Application 2020/60/90367/E

**Outline application for part demolition of existing building
and erection of detached dwelling adjacent to 111 Marsh Lane, Shepley**

title outline sketch plan proposal
number 19084D-02-P04
scale 1:200
size A1

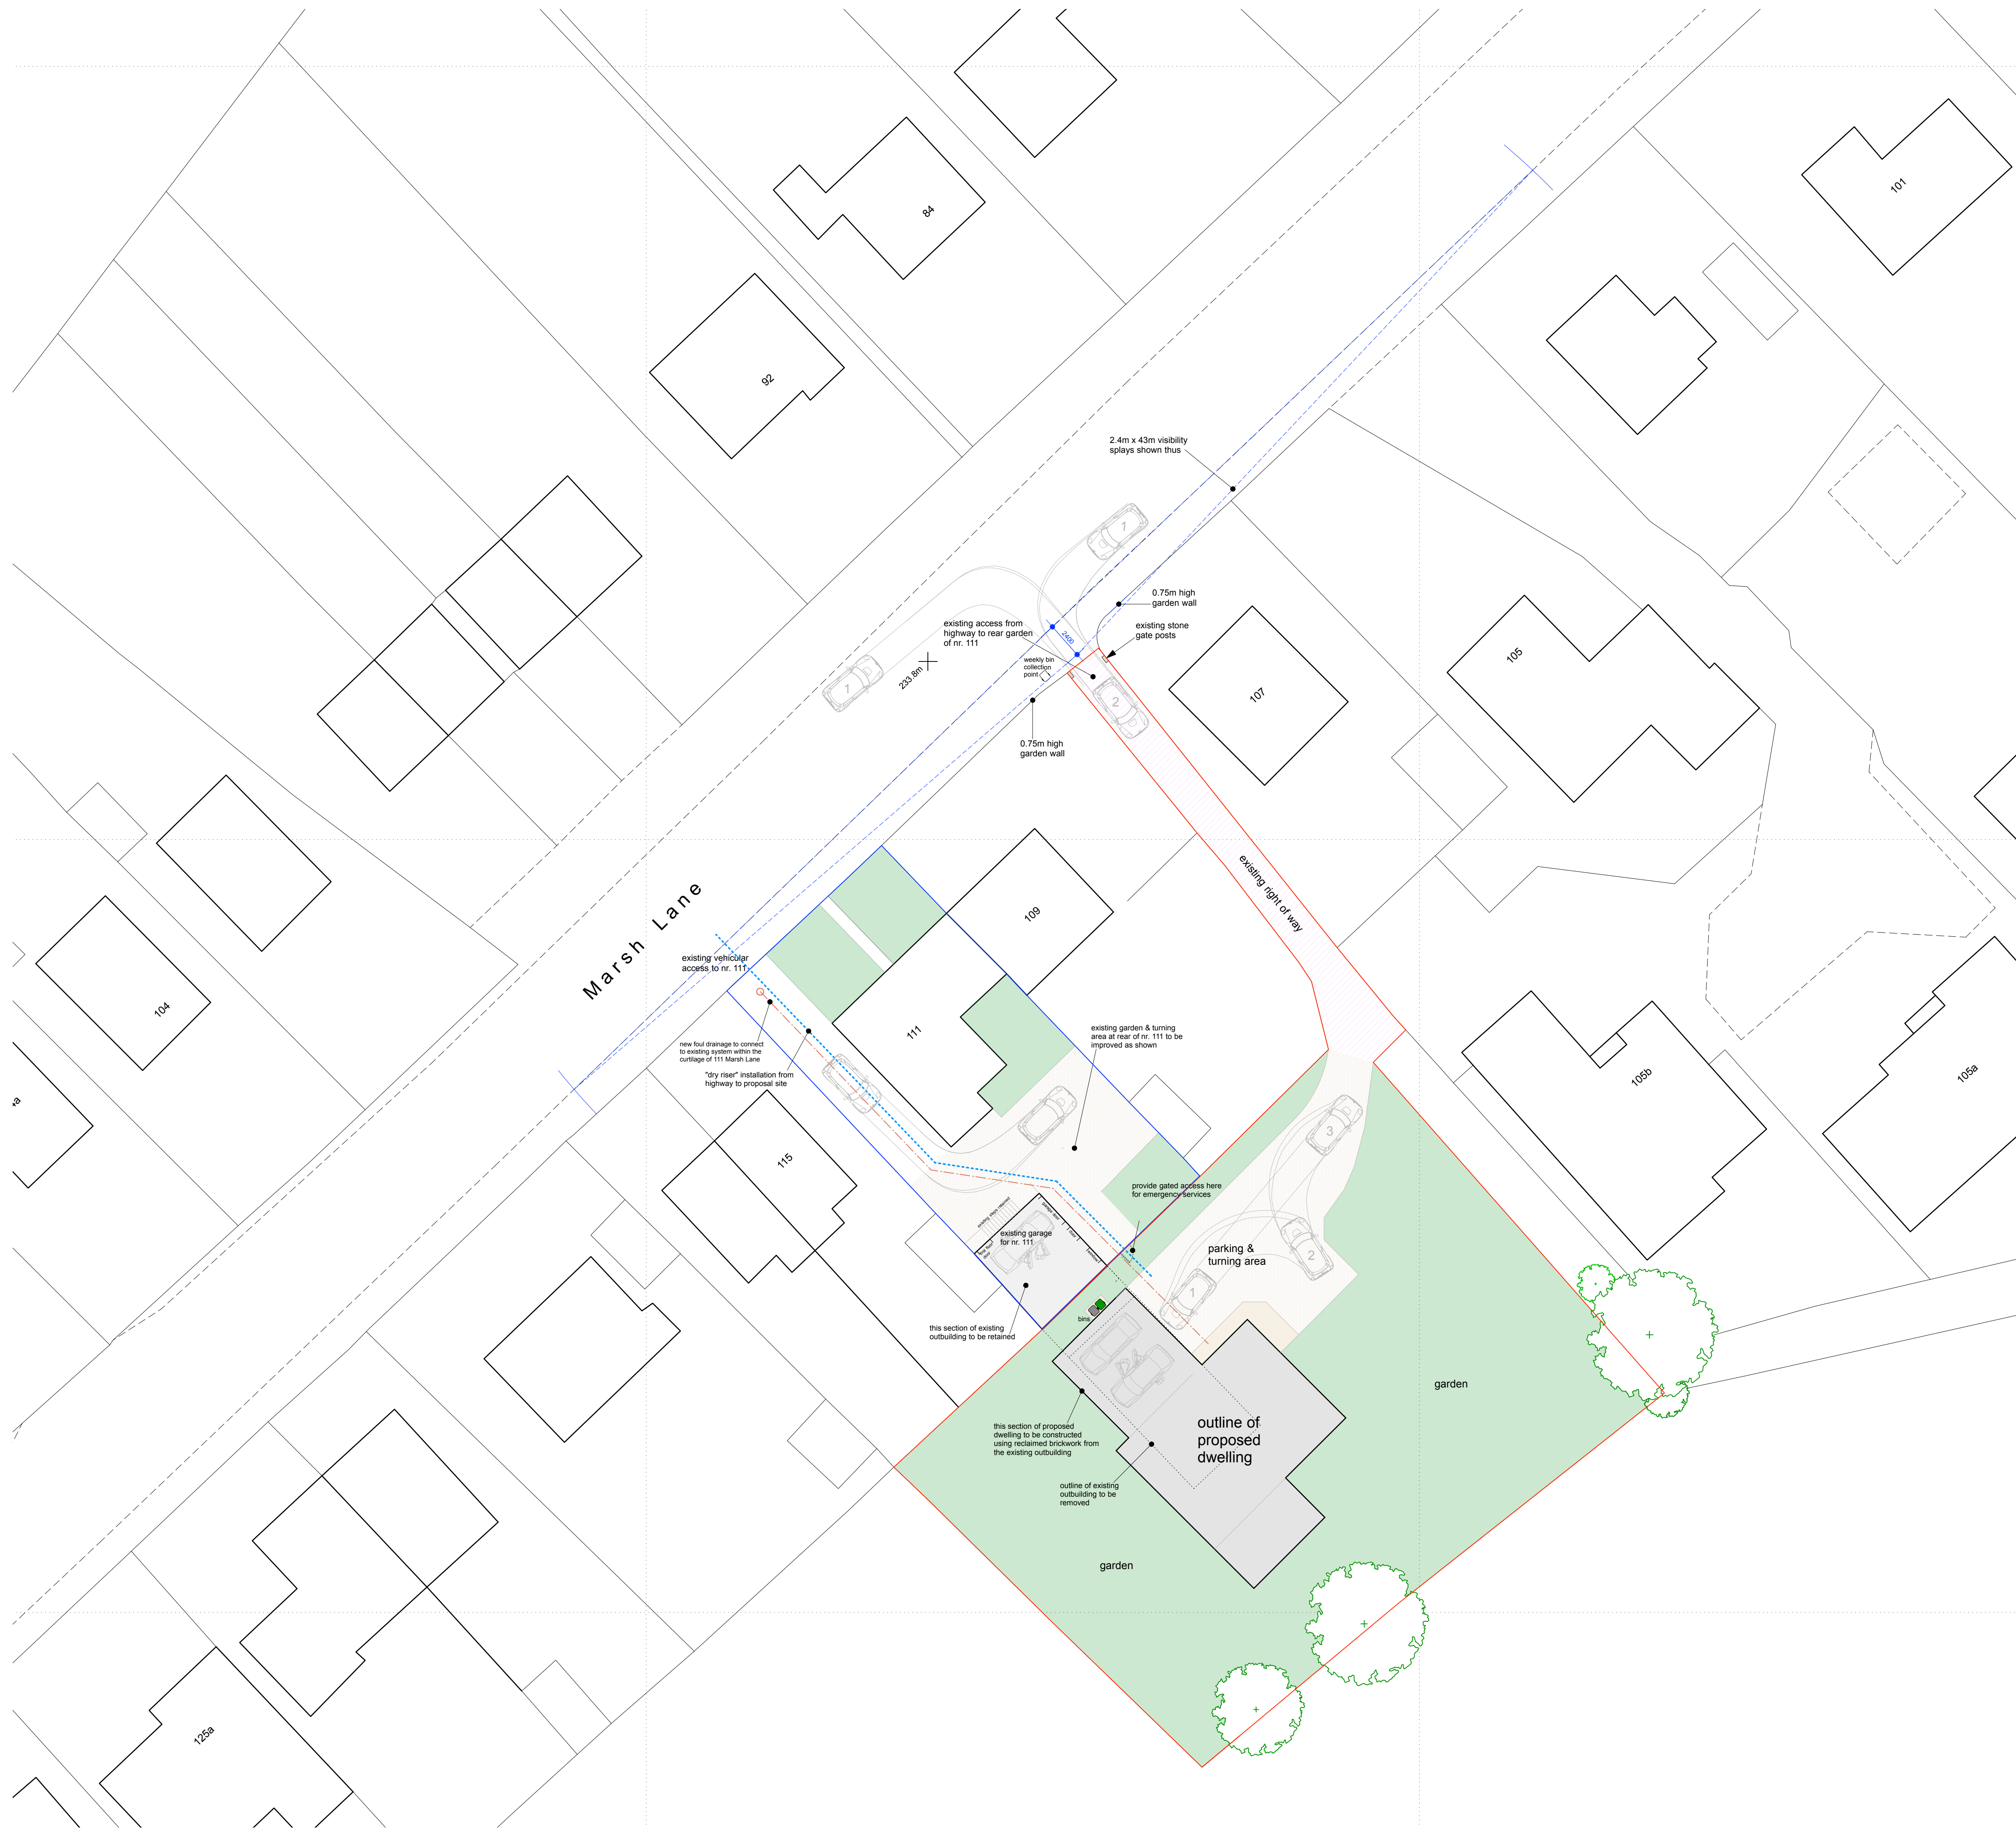
- Loss of my view and overshadowing of my house. The outline of the proposed new dwelling exceeds the outline of the applicant's existing outbuilding which is to be removed. I would be less concerned if the plans were amended so that the outline of the proposed new dwelling is the same, (so far as it encroaches on my view), as the existing outbuilding.

- It appears as though the access for emergency services to the new dwelling house will be through the garden of 111 Marsh Lane. Surely this cannot be acceptable, as if there are visitors parked at 111 Marsh Lane, how can they guarantee the access is kept clear. Surely this is dangerous and a risk to life.

- There is no bin collection point for the proposed dwelling house. The Kirklees bin wagon will not be able to access the property and the "bin-drag" distances from the property to the main road exceed the requirements set out in the Kirklees guidance.

- Whilst the Council no longer has set figures for space about building, should the proposed development have windows on the north facing elevation, these would only be 16 metres from the rear windows of my house which would not be acceptable in terms of privacy or amenity.

- The proposal appears to cover most of the rear garden of 111 Marsh Lane with tarmac, leaving no amenity space. Whilst the current owner may be okay with this, surely this would be unacceptable for future occupiers.
